To: [REDACTED]
Cc: [M25 Junction 28](#)
[Ashley, Charles](#)
Subject: Request for information from the Forestry Commission.
Date: 20 January 2021 10:37:52
Attachments: [TR010029-000364-20210112_2528 Written Questions_FINAL.pdf](#)

Application by Highways England for the M25 Junction 28 improvement scheme (the Proposed Development)
The Examining Authority's Written Questions and Requests for information (WQ1)
Issued on Wednesday 13 January 2021

Project Title		M25 Junction 28	
Drawing Title		FIGURE 5.8 AIR QUALITY RECEPTORS	
Drawing Number		HE551519 - ATK - EAQ XX - GS - GI - 000008	
Original Size: A3	Scale: 1:7,500	Project Ref. No: --	Sheet: 1 of 1 Rev: C01

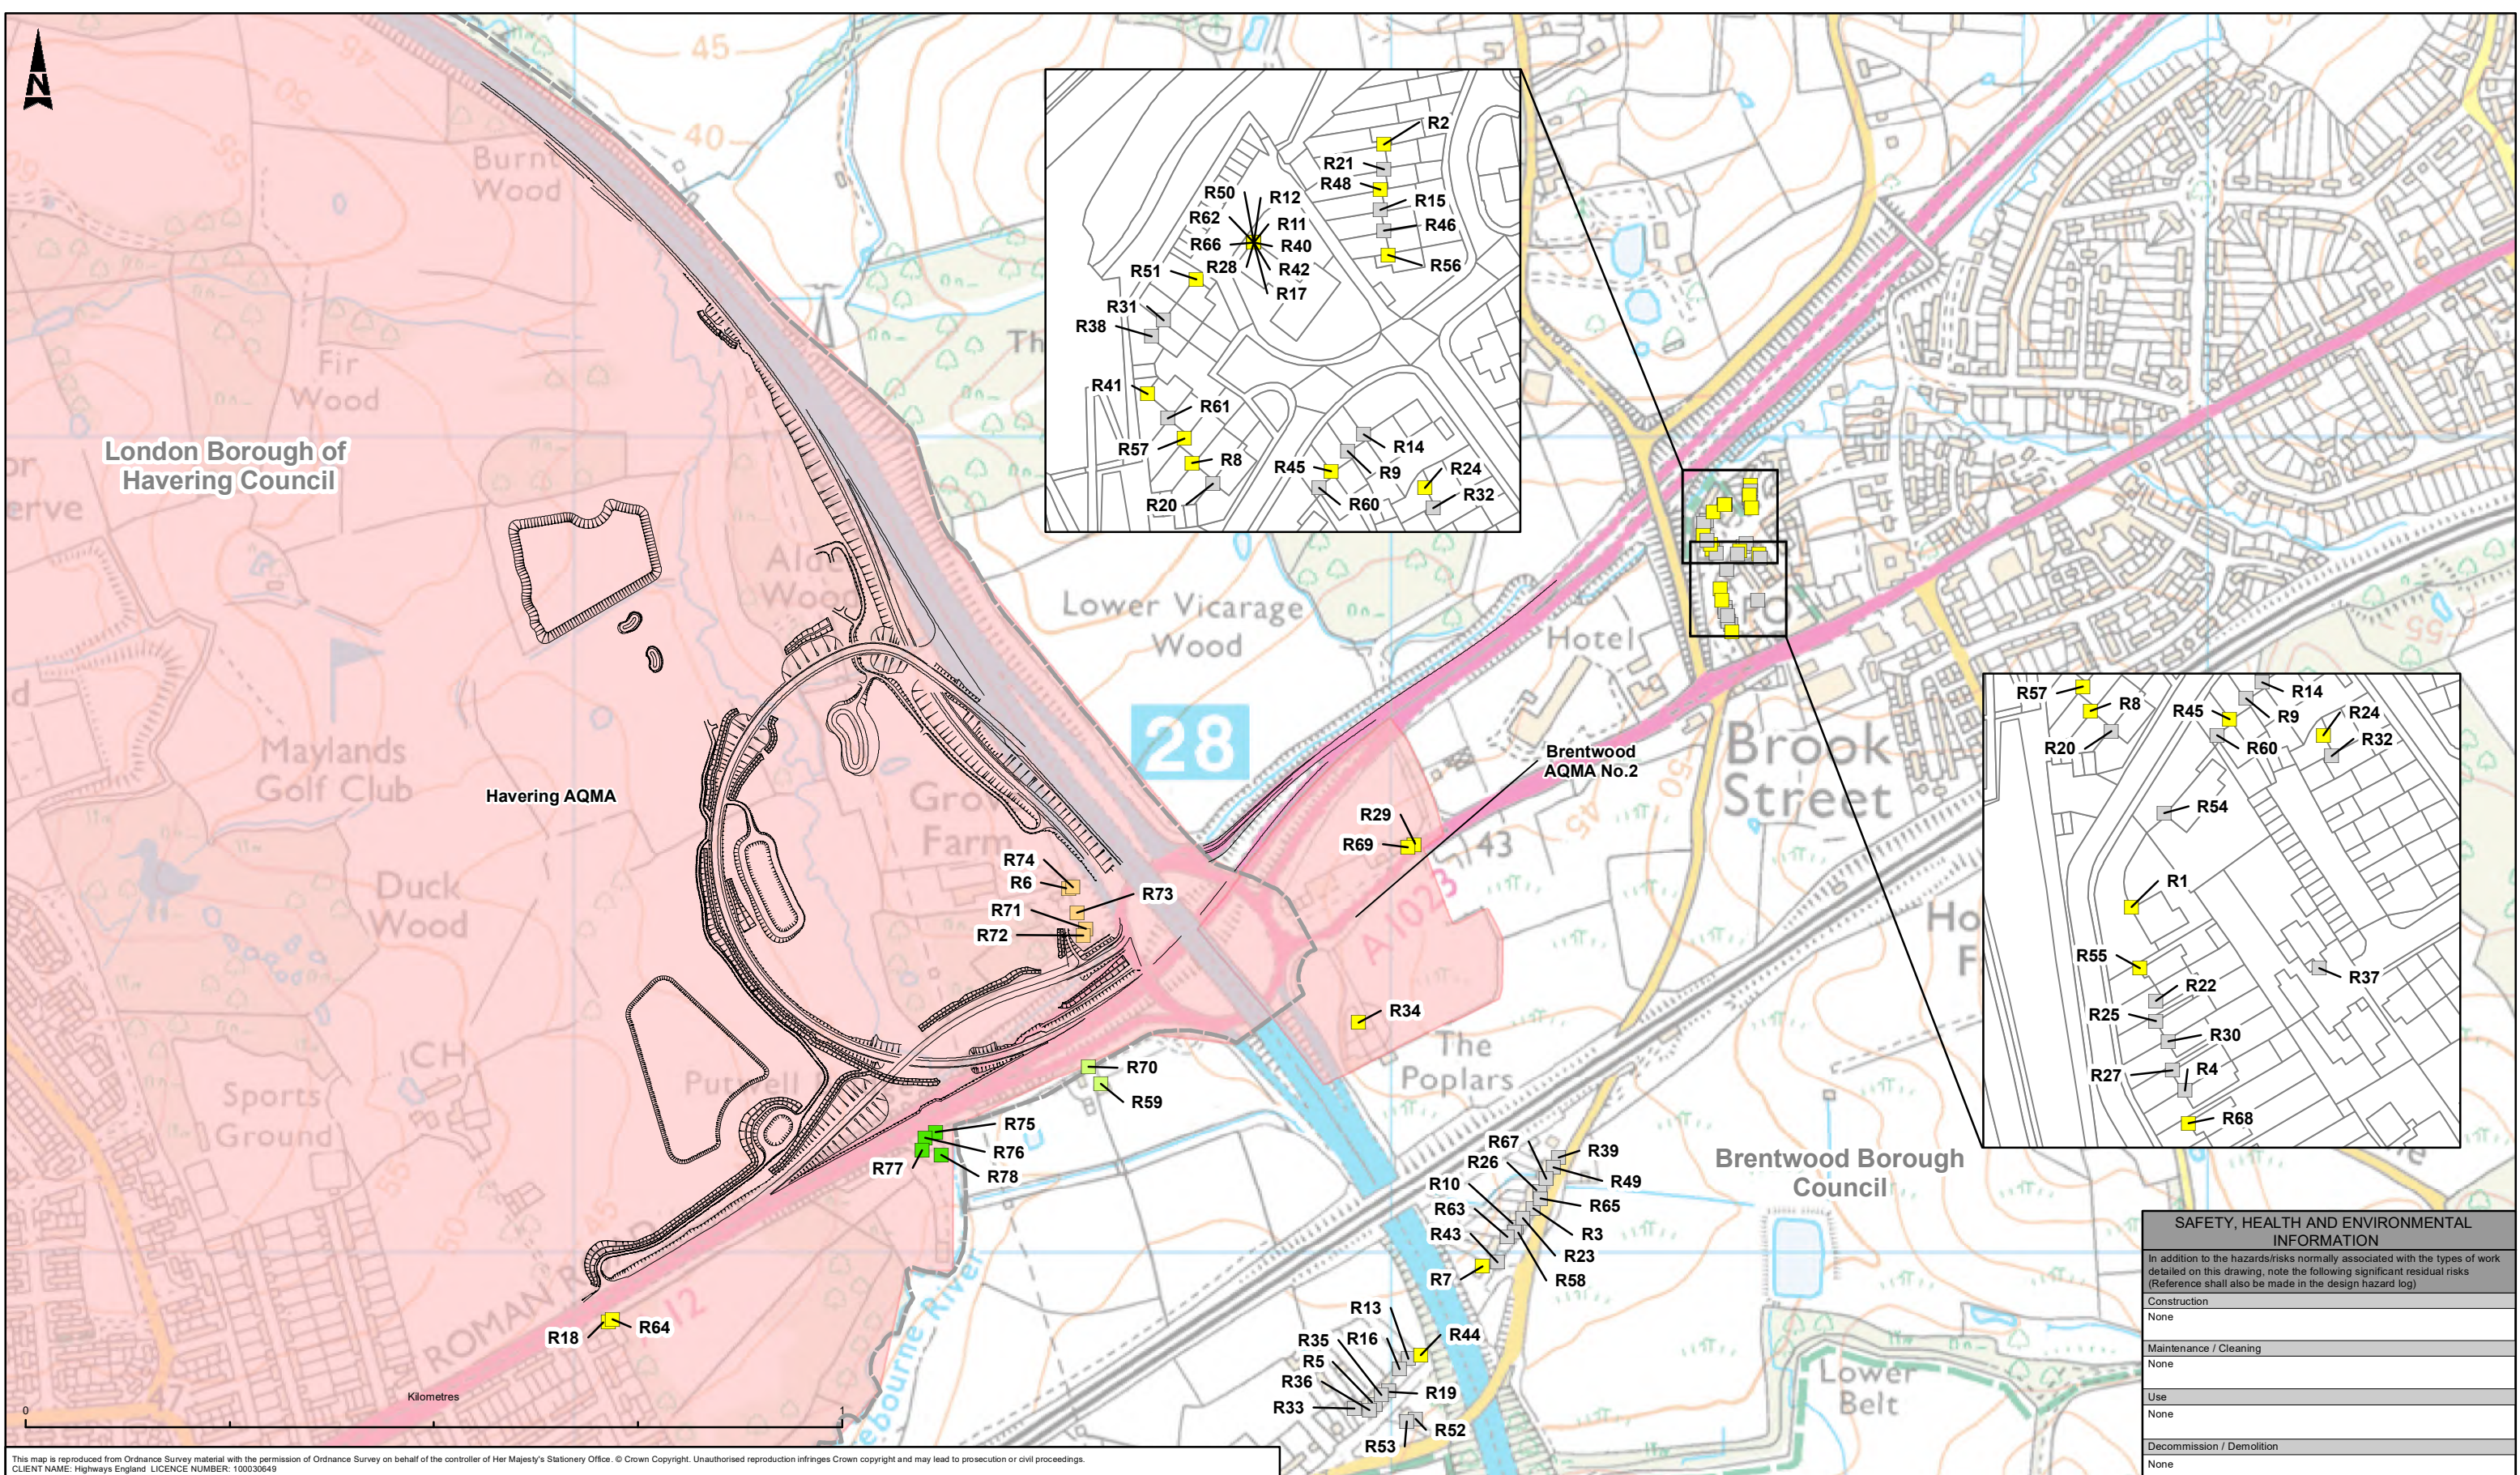
The Applicant	<p>5.1 of the Air Quality Appendix [APP-052]. However, R79 does not appear on Figure 5.8 [APP-040]. Moreover, the coordinates stated for R79 appear to be within the Order limits of the Proposed Development, and therefore is unlikely to be an area of use by the golf club once construction has commenced. It is also noted that receptor R47 is not depicted on Figure 5.8.</p> <p>Explain the anomalies and provide the exact location of R79 and R47 on a figure which also includes the Proposed Development's Order limits.</p>
AQ 1.8	<i>Methodology</i> The Applicant	<p>Table 5.8 of the Air Quality Appendix [APP-052] states that R47 and R79 are selected for comparison with the 1-hour mean NO₂ air quality objective, and / or 24-hour mean PM10 UK National Air Quality Strategy (AQS) objective.</p> <p>Explain why these two receptors were chosen over other receptors.</p>
AQ 1.9	<i>Methodology</i> The Applicant	<p>The construction air quality assessment in Chapter 5 of the ES [APP-027] omits a methodology detailing how the magnitude of impact and the significance of effect are categorised.</p> <p>Explain in detail how the assessment of construction impacts, with regards to the emission of dust to nearby receptors, has been undertaken in terms of categorising the magnitude of impacts and significance of effect.</p>
